Ribble Valley Borough Council
Housing & Development Control

Application no: **3/2022/0467**

Address: **36 Painter Wood Whalley Old Road Billington BB7 9JD**

Proposal: **Demolition of existing house and erection of a replacement dwelling with associated external works. Resubmission of 3/2021/1122.**

PROPOSED PLANS

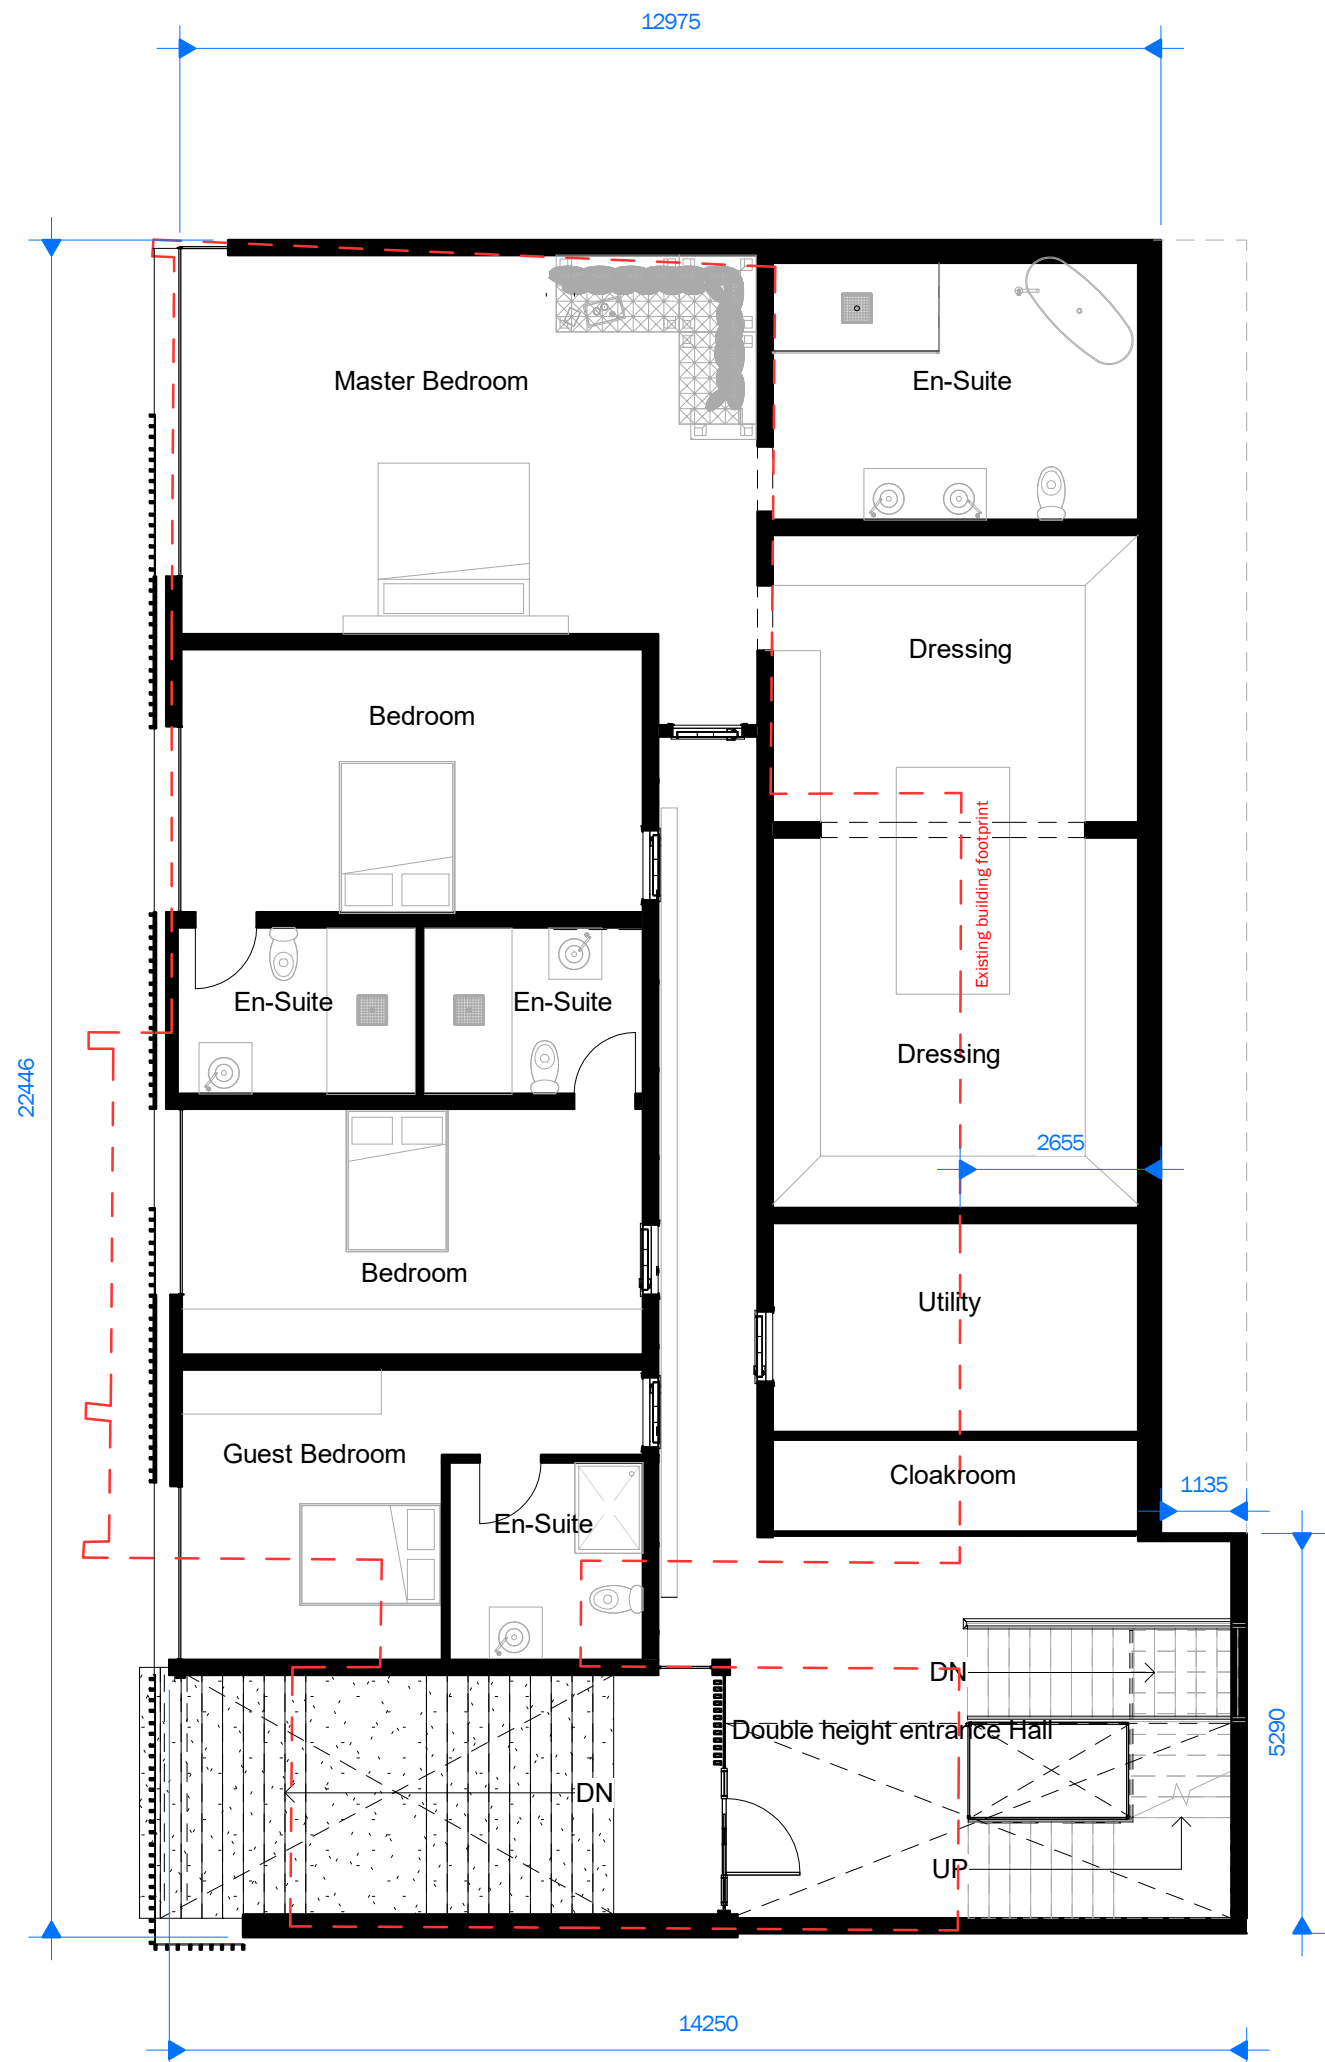
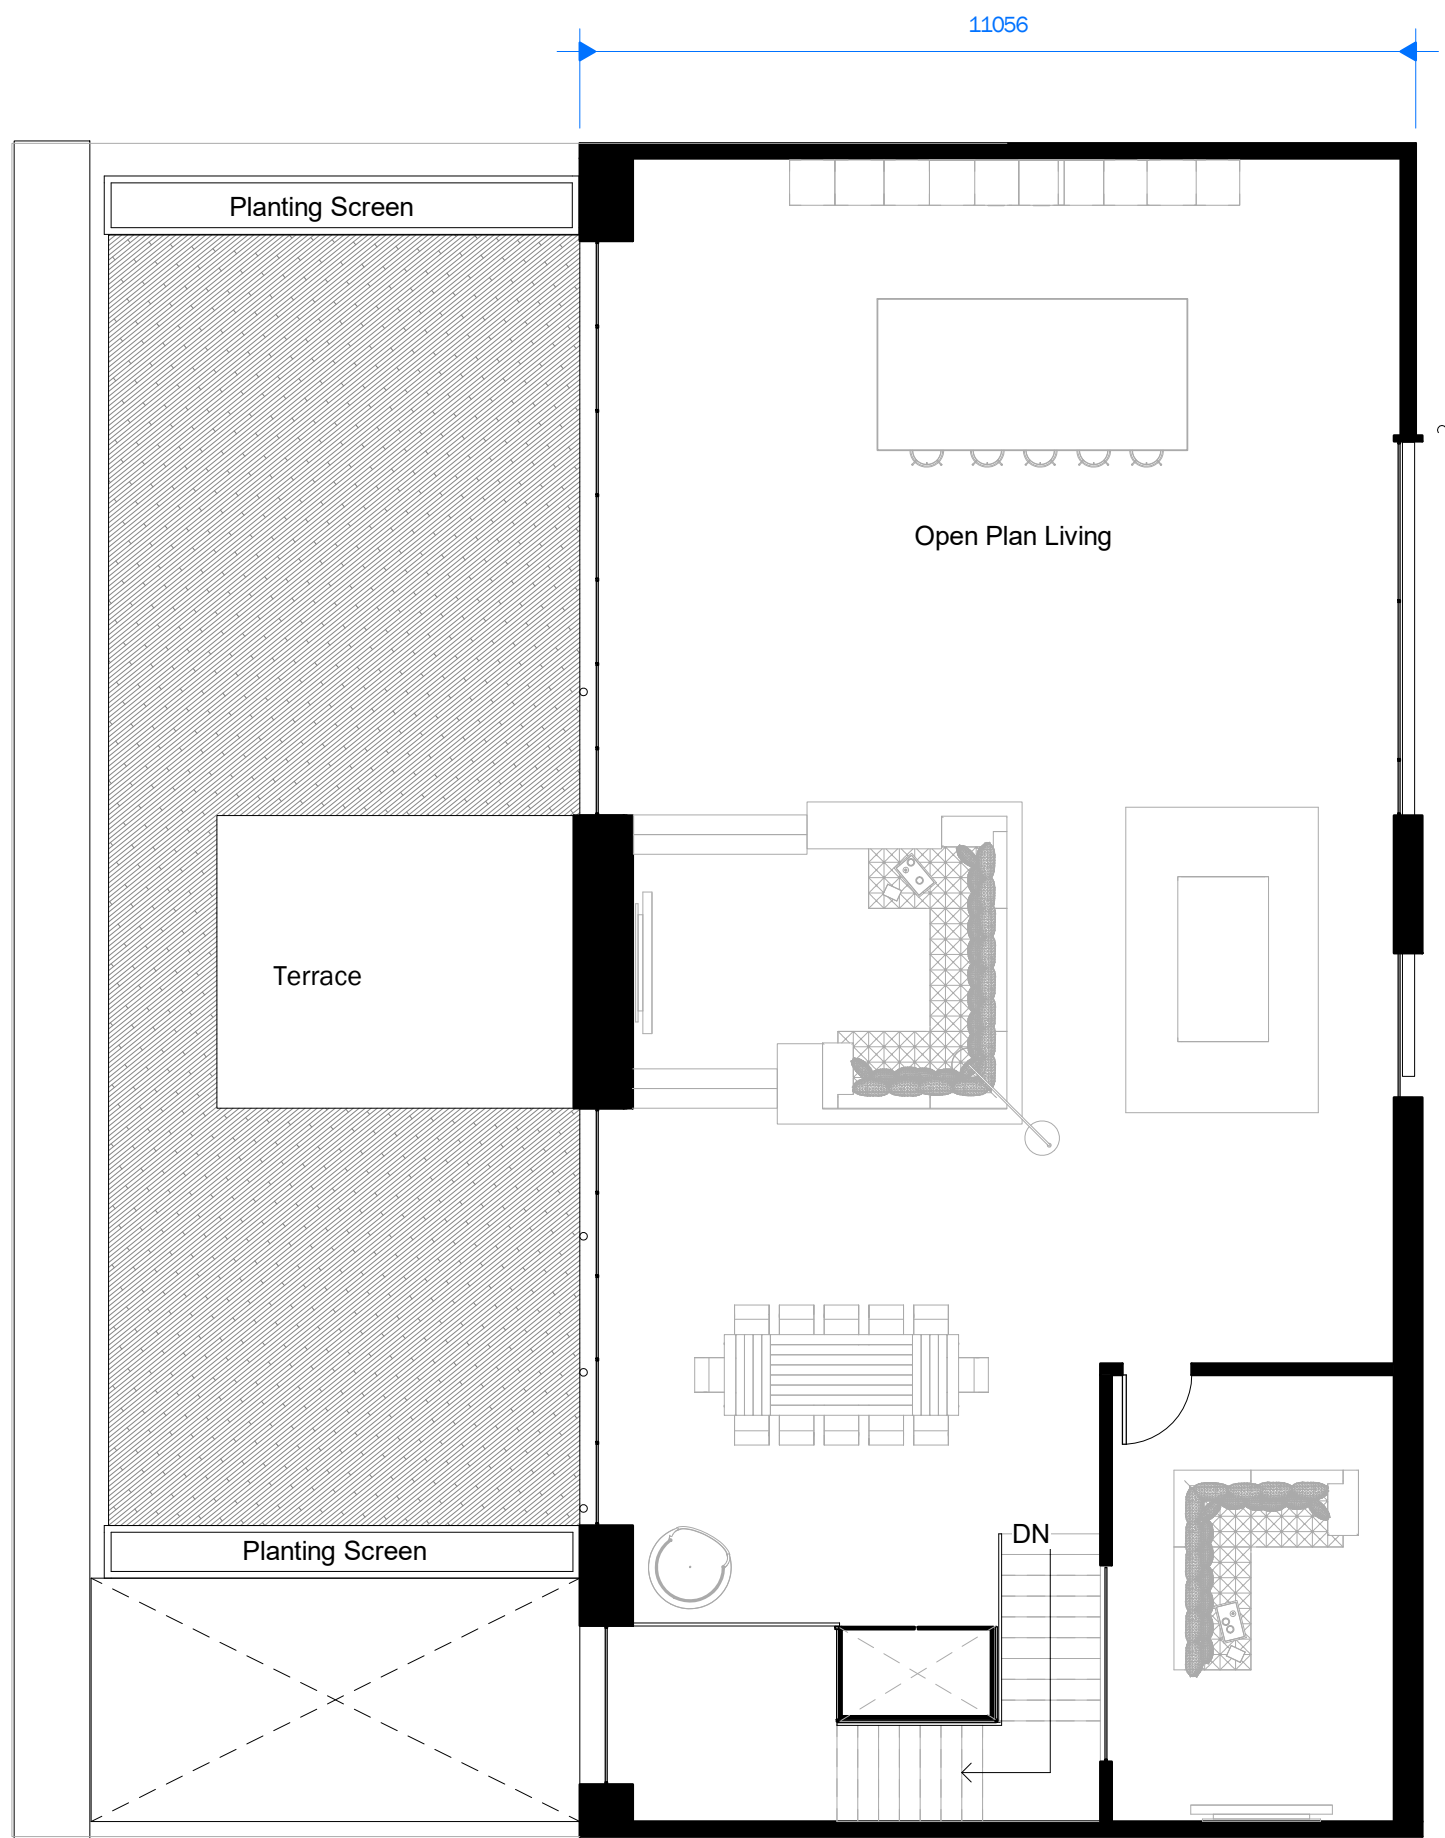
The LHA have reviewed Peter Hitchen drawing number A1.4 titled "Proposed Plans" and Peter Hitchen drawing number A1.5 titled "Proposed Site Plan" and are satisfied that the parking arrangements complies with the parking standards found in the Joint Lancashire Structure Plan. Therefore, the LHA have no further comments to make.
